Recommendation Report for Planning Permission for Works or Extension to a Dwelling

REF NO: EP/155/18/HH

LOCATION: 36 Warren Crescent
East Preston
BN16 1BJ

PROPOSAL: Single storey rear extension with demolition of existing sun room and kitchen and alterations to garage

DRWG TITLE: **Proposed Elevations**
DRWG No: **1018_301**
REV: -

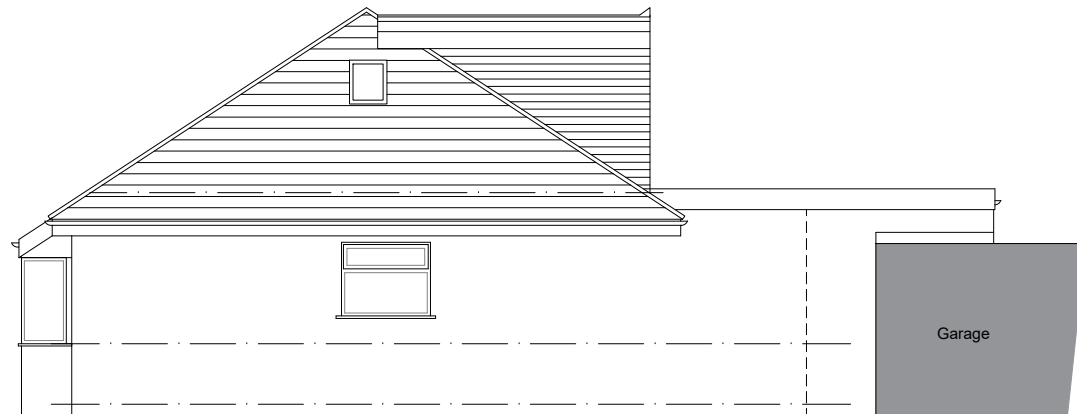
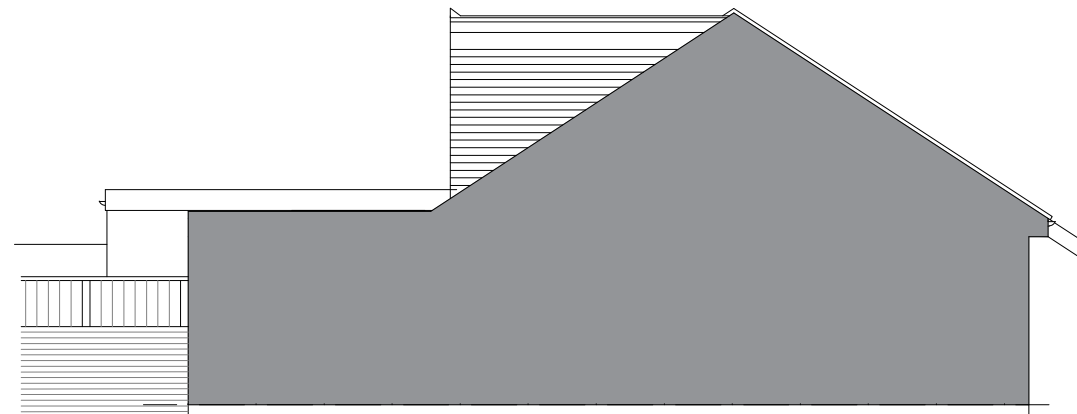
The proposed development is considered to appear subservient and well integrated with the host dwelling, resultant of its modest scale, and matching materials. The extensions maximum height is 2.5m lower than the ridge height of the host dwelling. These factors allow the extensions to appear sympathetic to the established character of the host dwelling.

The proposed development is not considered to cause undue levels of overshadowing towards neighbouring properties, not appear overbearing. Whilst the extension is approximately 1m to the boundary to the East, the roof design is such that the roof height when closest to the boundary is 3m, which is considered to alleviate any potential overbearing impact on the neighbour to the East. To the West, the extension is sited over 3m from this boundary, as a result of an existing garage. Therefore, the proposed development is not considered to have any significant impact on overshadowing, or loss of
